FINAL
DRAINAGE PLAN AND REPORT

FUEL MISSIONS

A PROPOSED CHURCH AT 10695 LINDBERGH ROAD

December 15, 2020

DRAWN BY: D.E. WATTS		APPROVED BY:		REVISIONS		PROJECT		SHT. NAME		SHT. NO.	
DATE: 12-9-20		PROJ. NO.				16965 LINDBERGH ROAD		DRAINAGE PLAN		1	
DWG. NO.: 20-5449 01		DWG.				N1/2, N1/2, NW1/4, SE1/4, SEC. 22, T.11S., R.67W.				OF	
SURVEYED BY: DEV. ES. 4-29-20 12-4-20						EL PASO COUNTY				1

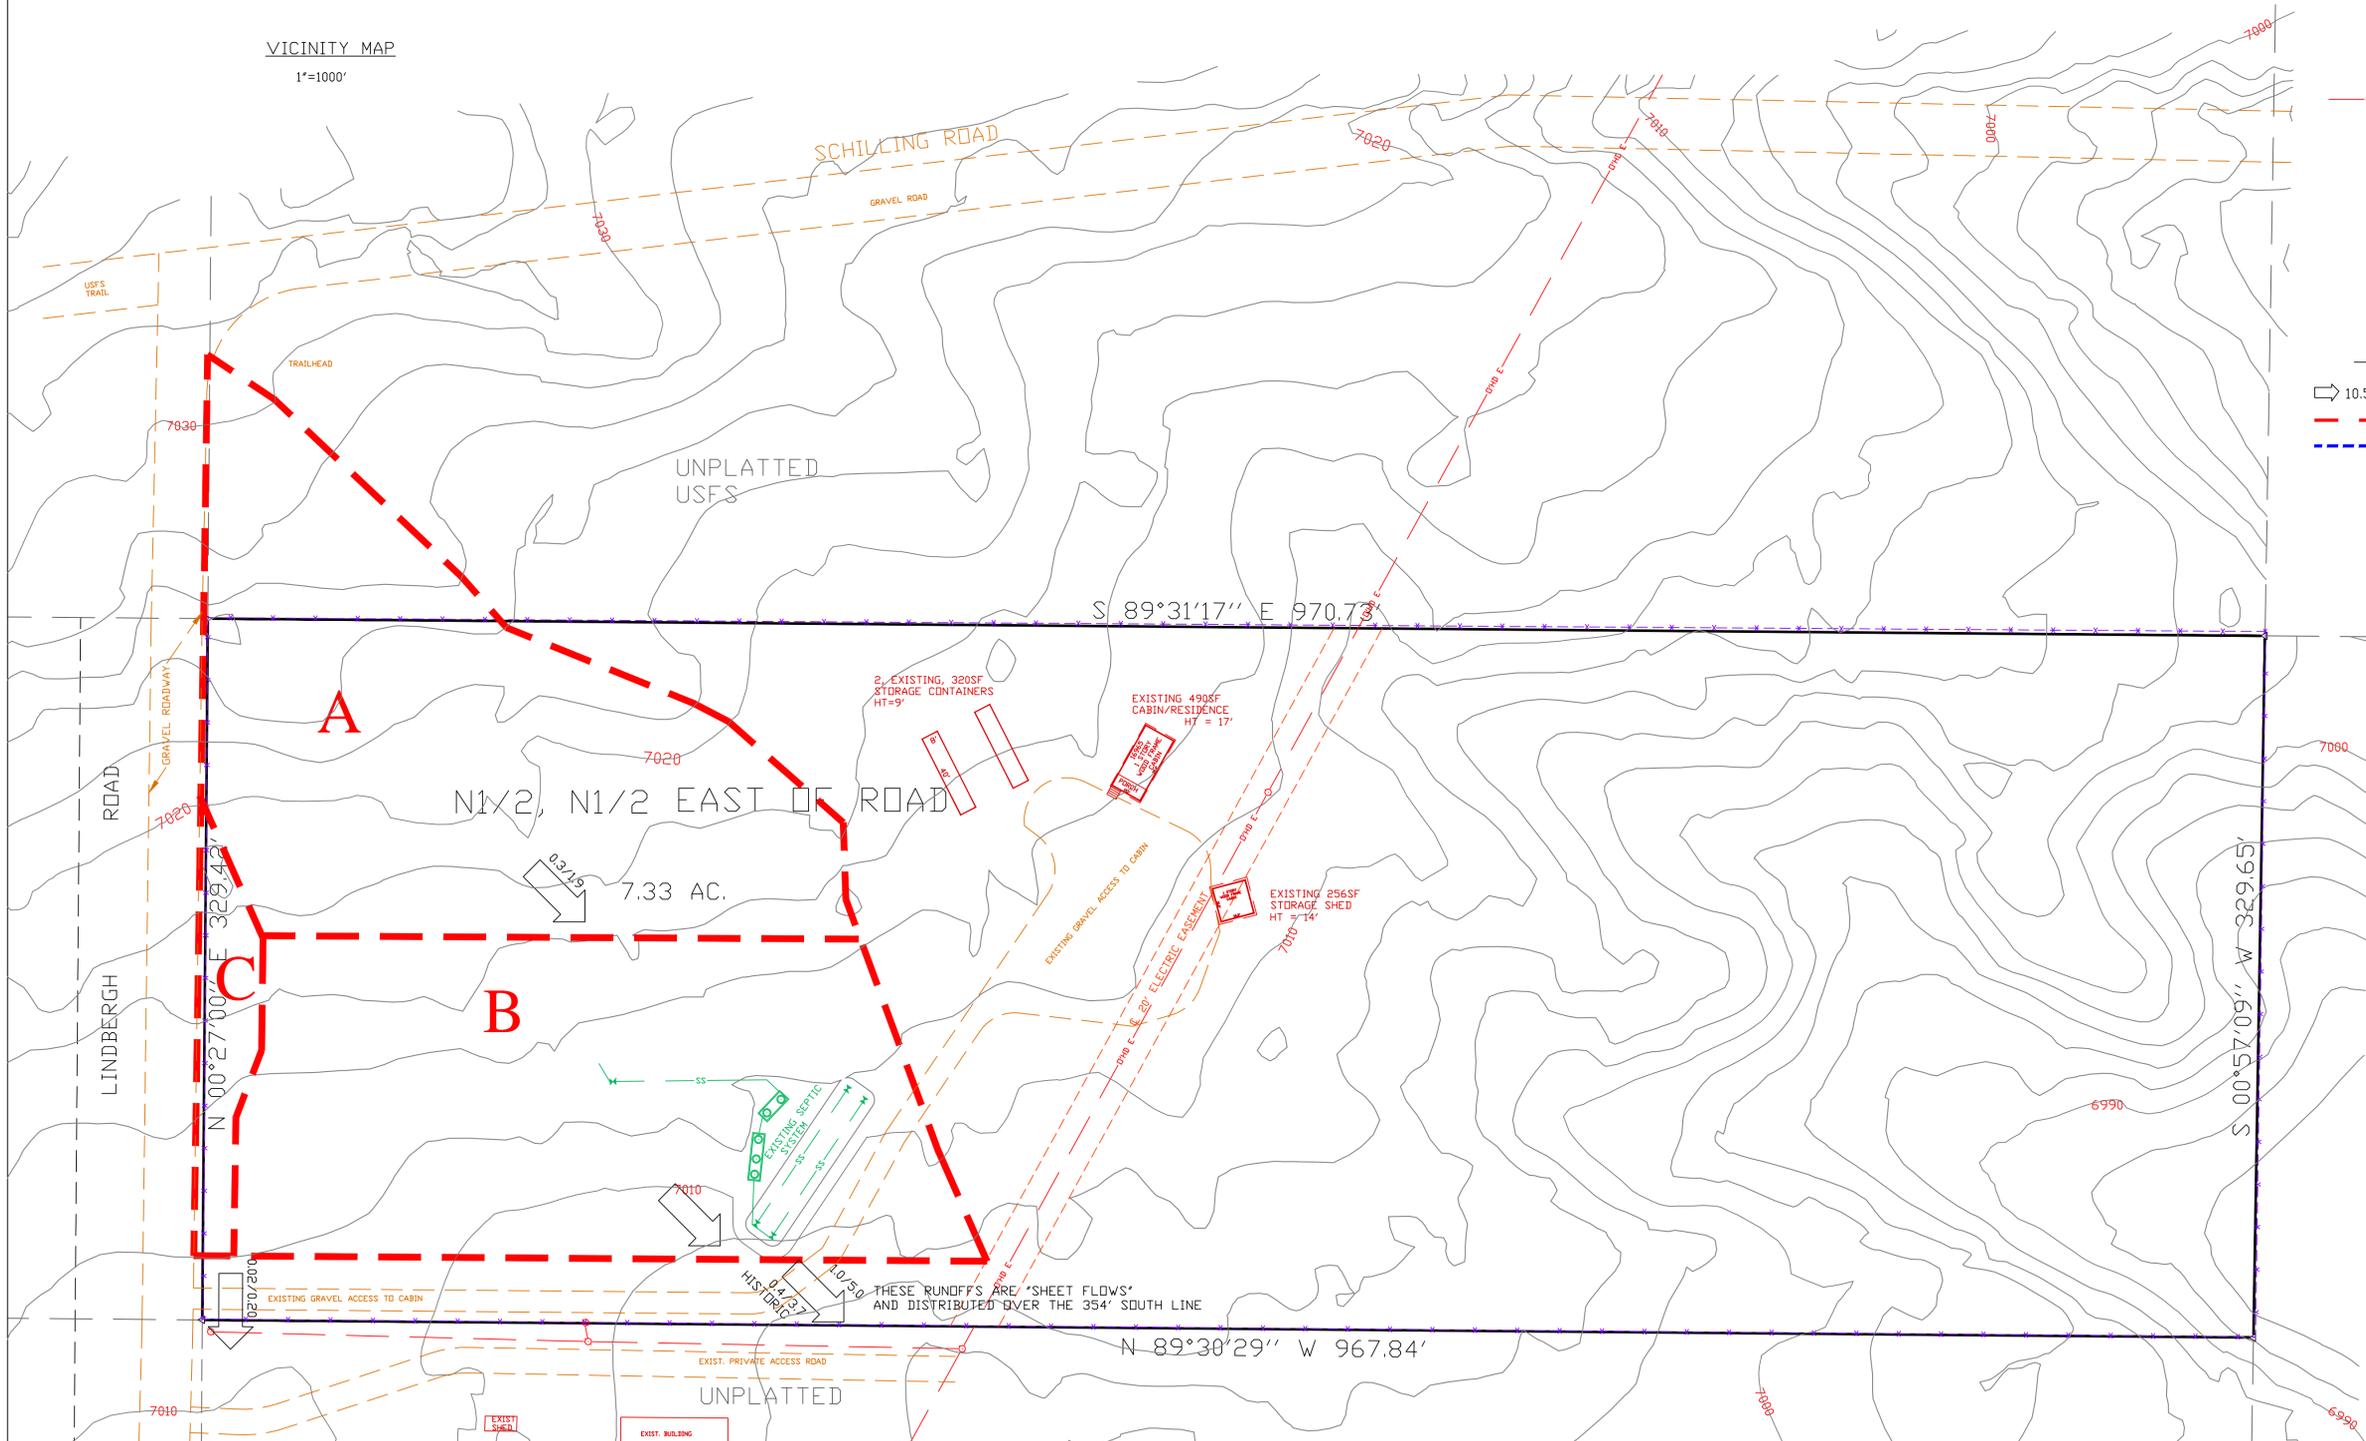
Please discuss in your report the developed flow that will be conveyed to the culvert. Please state how this compares to the historic flow at this location. Also provide a design calculation for the culvert.

Please show the driveway to the existing cabin/residence. If a new driveway is proposed please include it in your analysis. A new driveway shall be included as part of the disturbed area.

Please show the driveway to the existing cabin/residence. If a new driveway is proposed please include it in your analysis. A new driveway shall be included as part of the disturbed area.

Please discuss in your report the developed flow that will be conveyed to the culvert. Please state how this compares to the historic flow at this location. Also provide a design calculation for the culvert.
